28/11/2019

**Sydney Fish Market  
Concept and Stage 1 (SSD-8924) and Stage 2 (SSD-8925)**

## **Attachment A – Key Issues**

Diagram: Proposed building shadow and existing shadows differentiated.

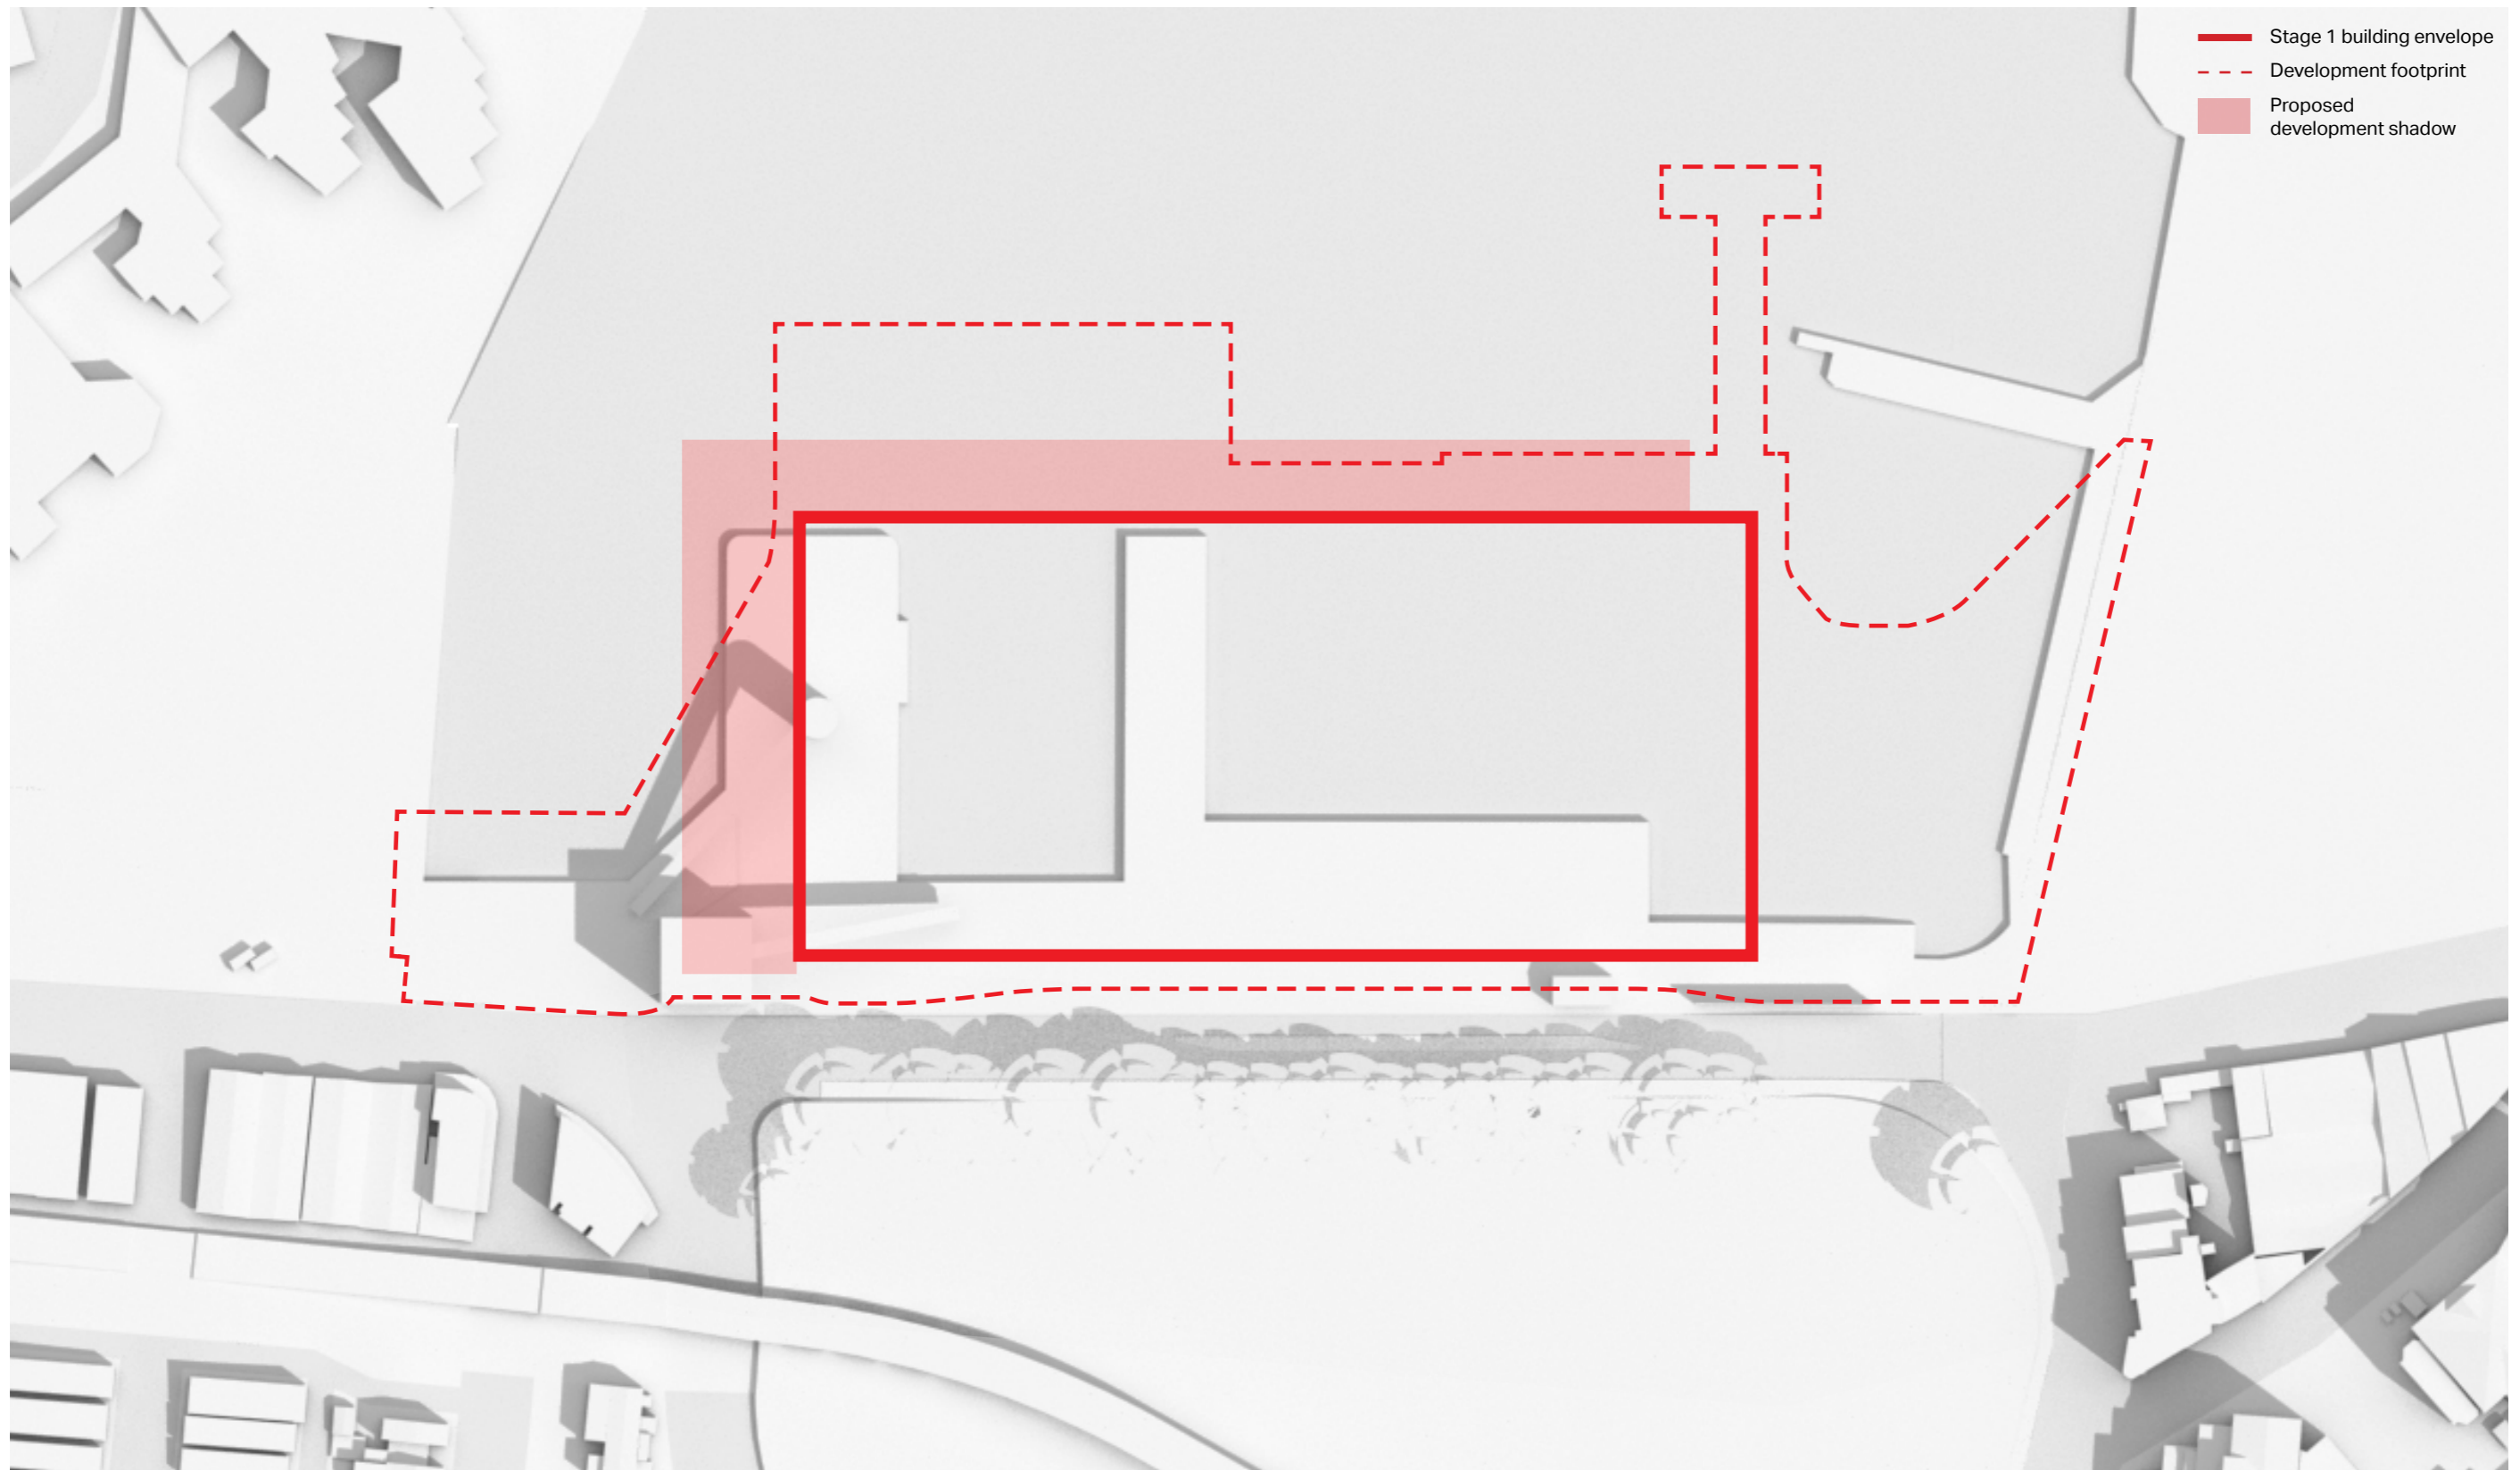
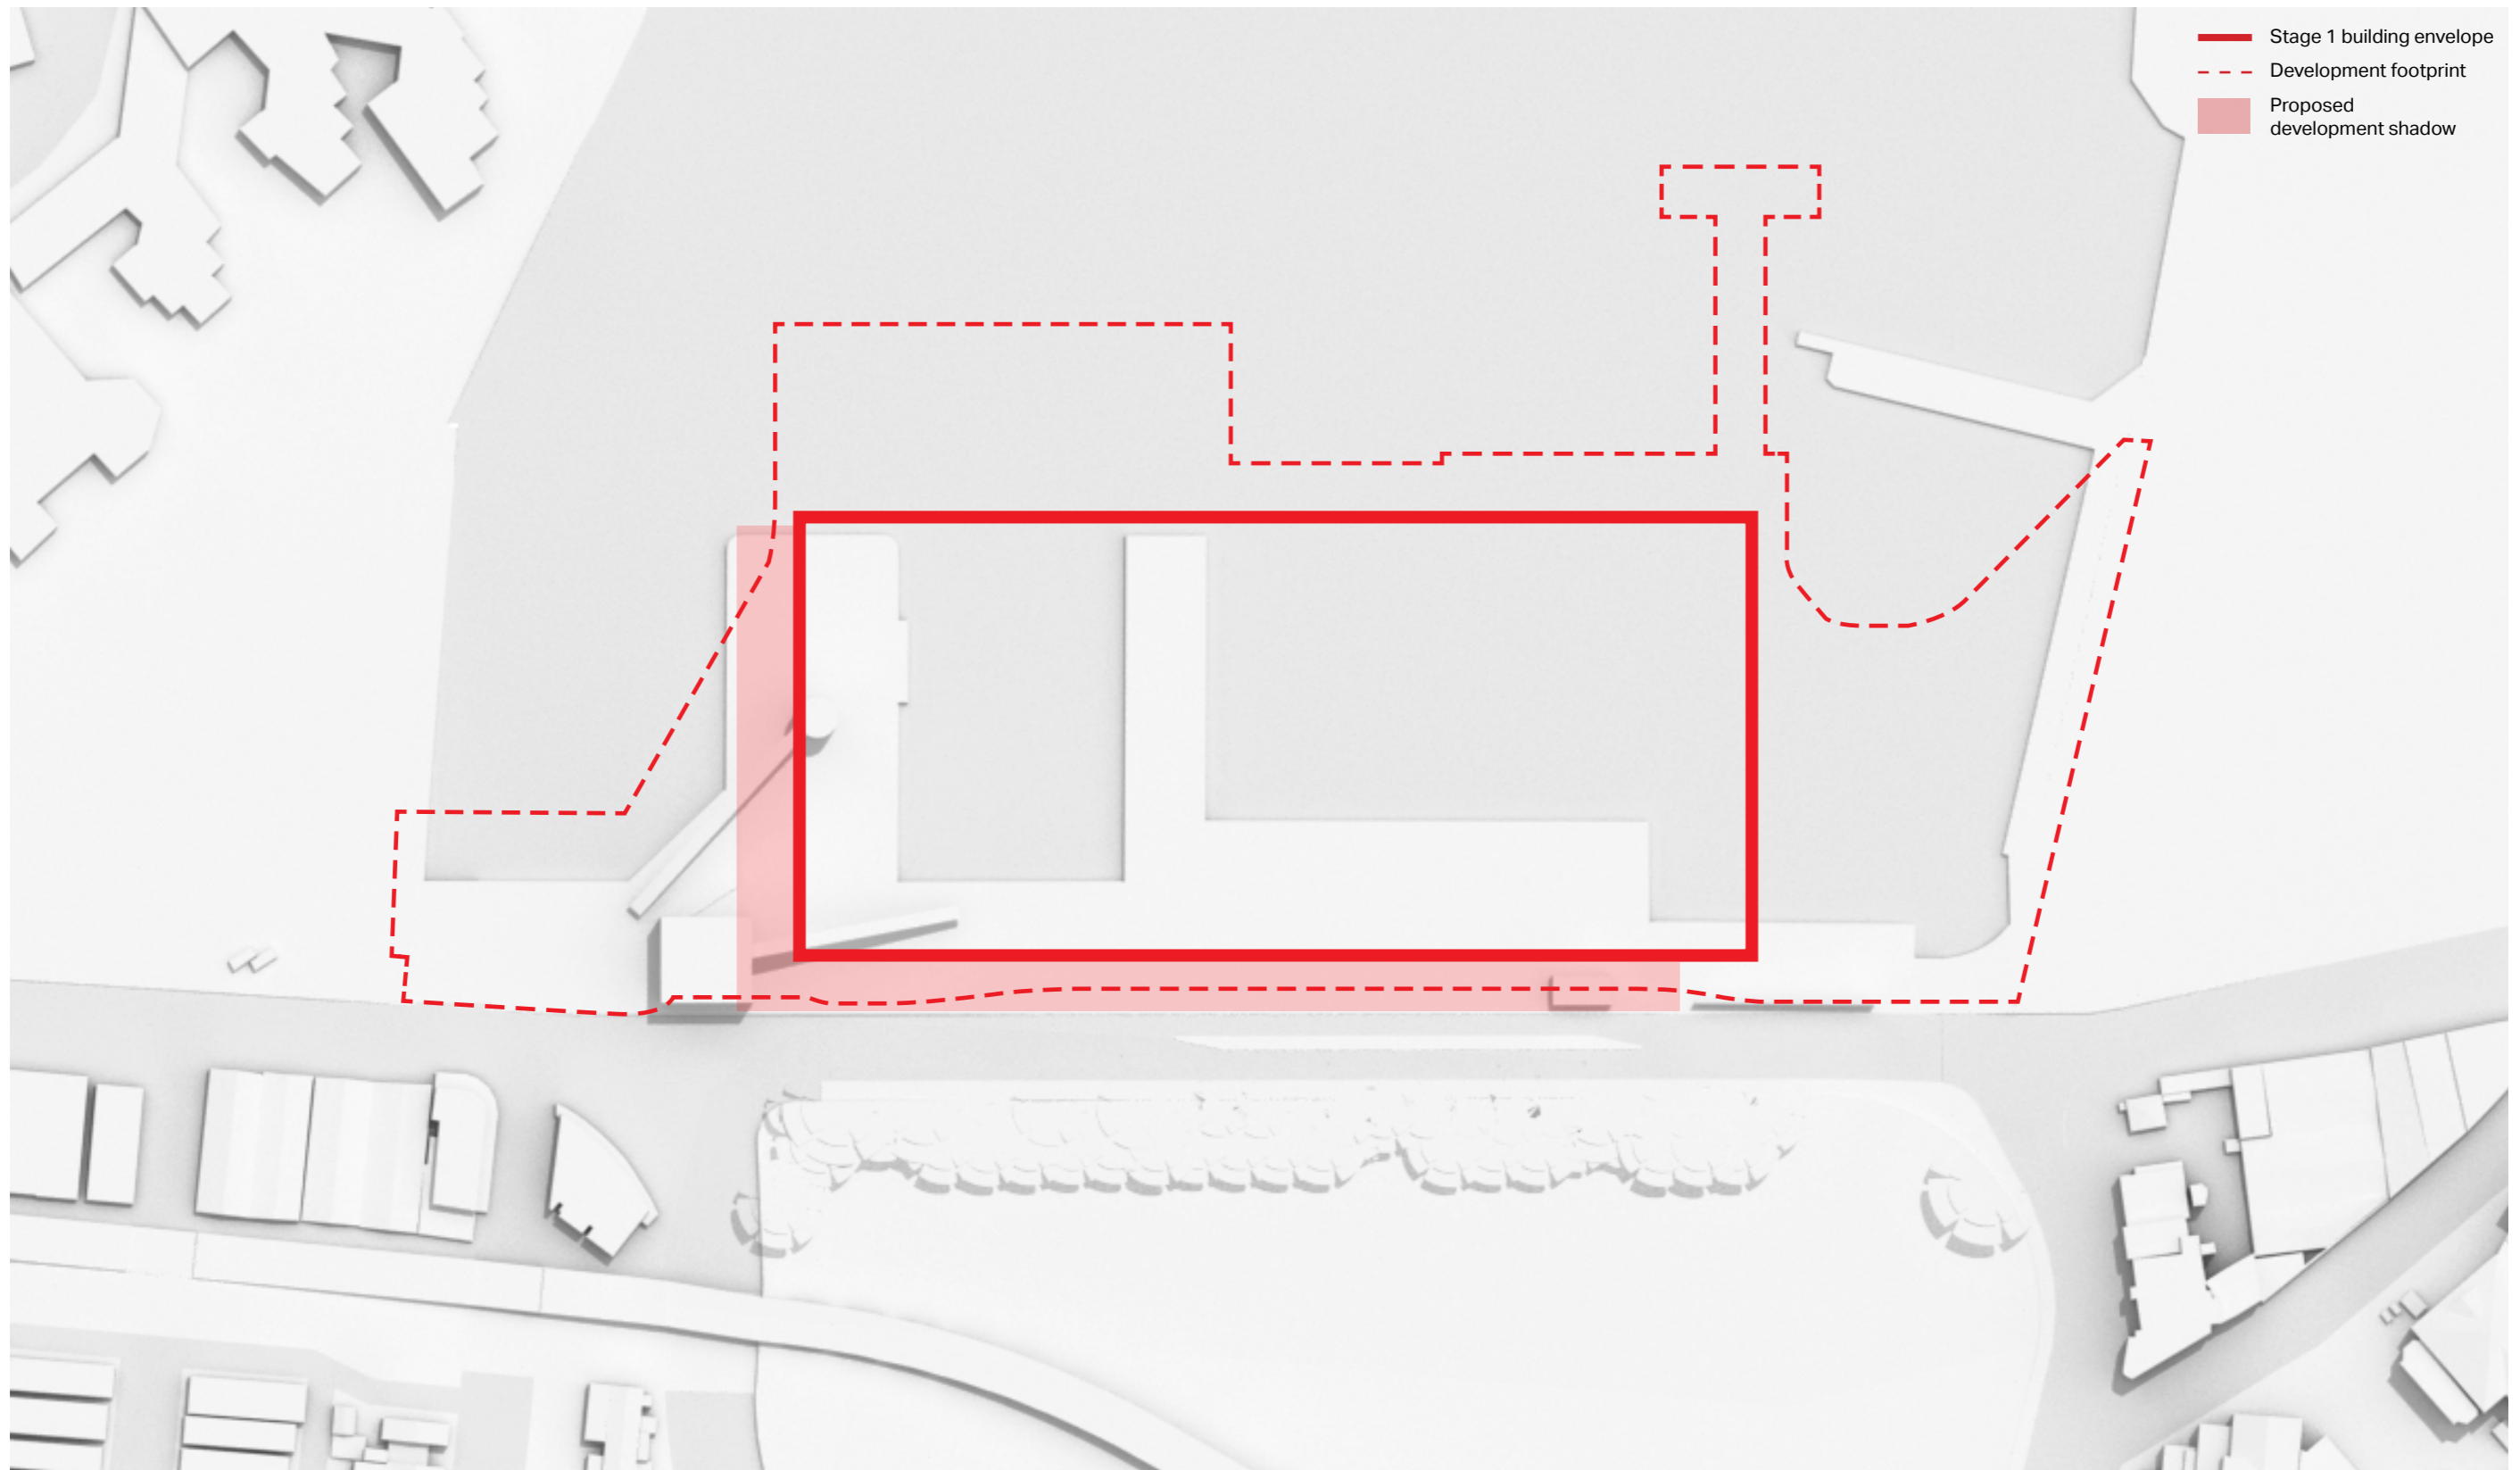
- (a) Provide a view impact assessment from within private properties surrounding the site, noting the visual impact assessment by Cloustone is from public areas only and private view impacts are raised as a concern in public submissions.
- (b) As noted within the Acoustic Assessment report, the project team were to further engage with the representatives of the residential apartments at 84 Wentworth Park Road to discuss the acoustic impacts and potential preferred additional mitigation measures. Details of the outcome of this engagement shall be provided.
- (c) Confirm the shadow diagrams included the survey data of existing trees and show/differentiate existing and proposed additional shadows relative to existing tree shadows as has been done for existing buildings (so the 'additional' shadows to Wentworth Park are clearer).
